Date: November 10, 2016

Reference: WC853-02F04(rev0)- WE Letter

RE: 80-88 REGENT STREET, REDFERN
Wind Impact Comments from the Department of Planning

MARIAN STREET

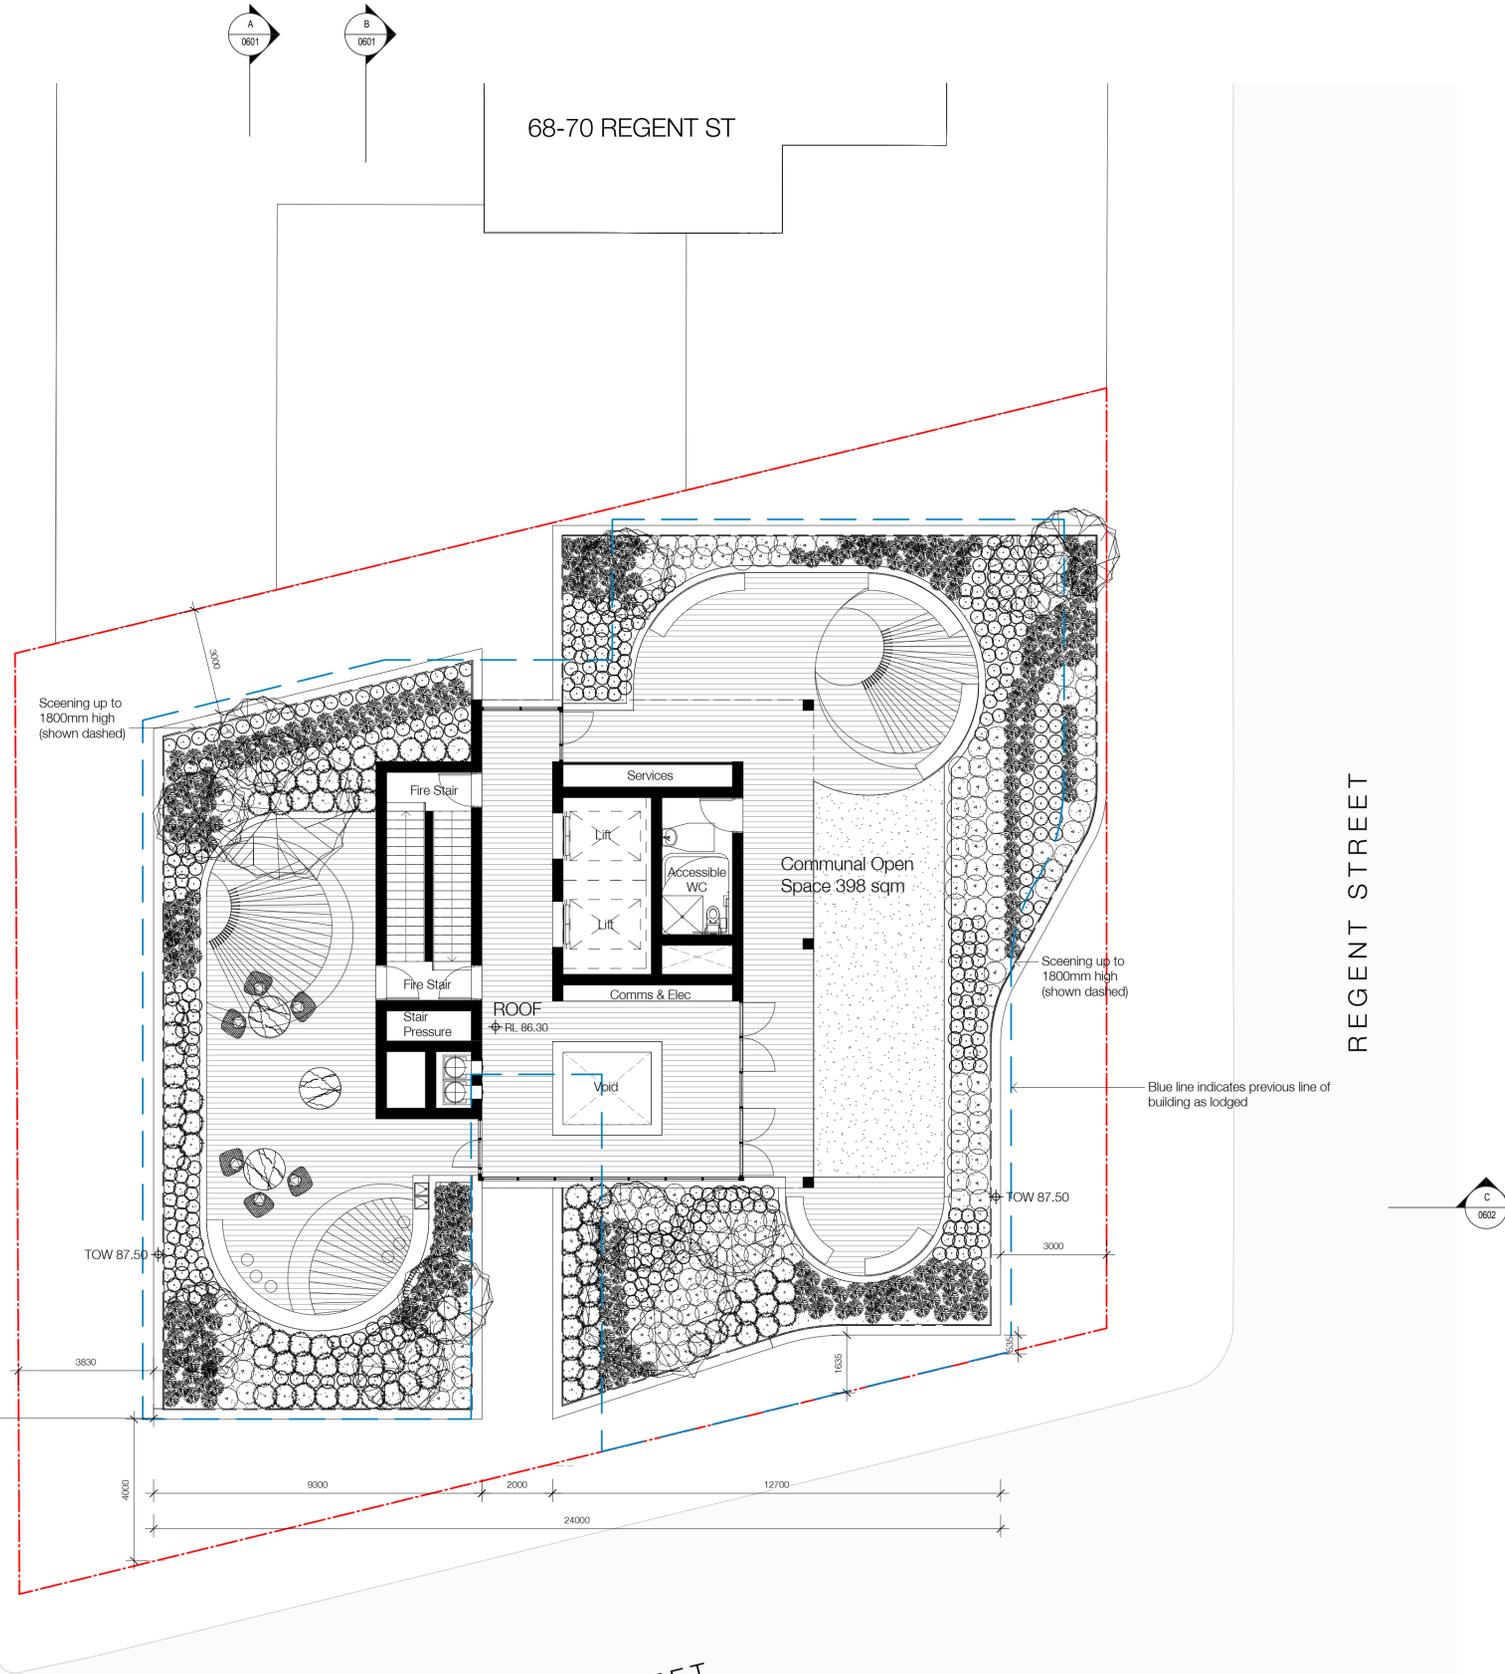
1. The increased impact of the wind conditions around the site with the inclusion of the proposed development when compared to the existing conditions and reference to the annual maximum gust criteria.
2. The setback along Marion Street should be increased from 3 metres to 4 metres to assist with reducing downwash effects.
3. Impact of the subject development to the adjacent developments and their associated outdoor areas, including the Iglu communal space.

2. Tuff measurements were undertaken during the wind tunnel study to determine the flow mechanism which impacts the wind conditions along Marian Street. This was noted to be governed by ground level effects due to the street alignment and not a downwash component off the tower which was the concern raised. The inclusion of an additional setback of the tower along Marian Street would therefore not provide any notable benefit to the ground level wind conditions. Based on the noted flow mechanism impacting Marian Street, recommended porous screen treatment at the corner of Marian Street and Regent Street is effective in mitigating the side-stream effect around the corner of the building at ground level by reducing the large pressure differential around the corner. Furthermore the inclusion of an awning along this aspect in the areas noted in the wind report provided some localised improvement due to downwash off the podium section of the façade.
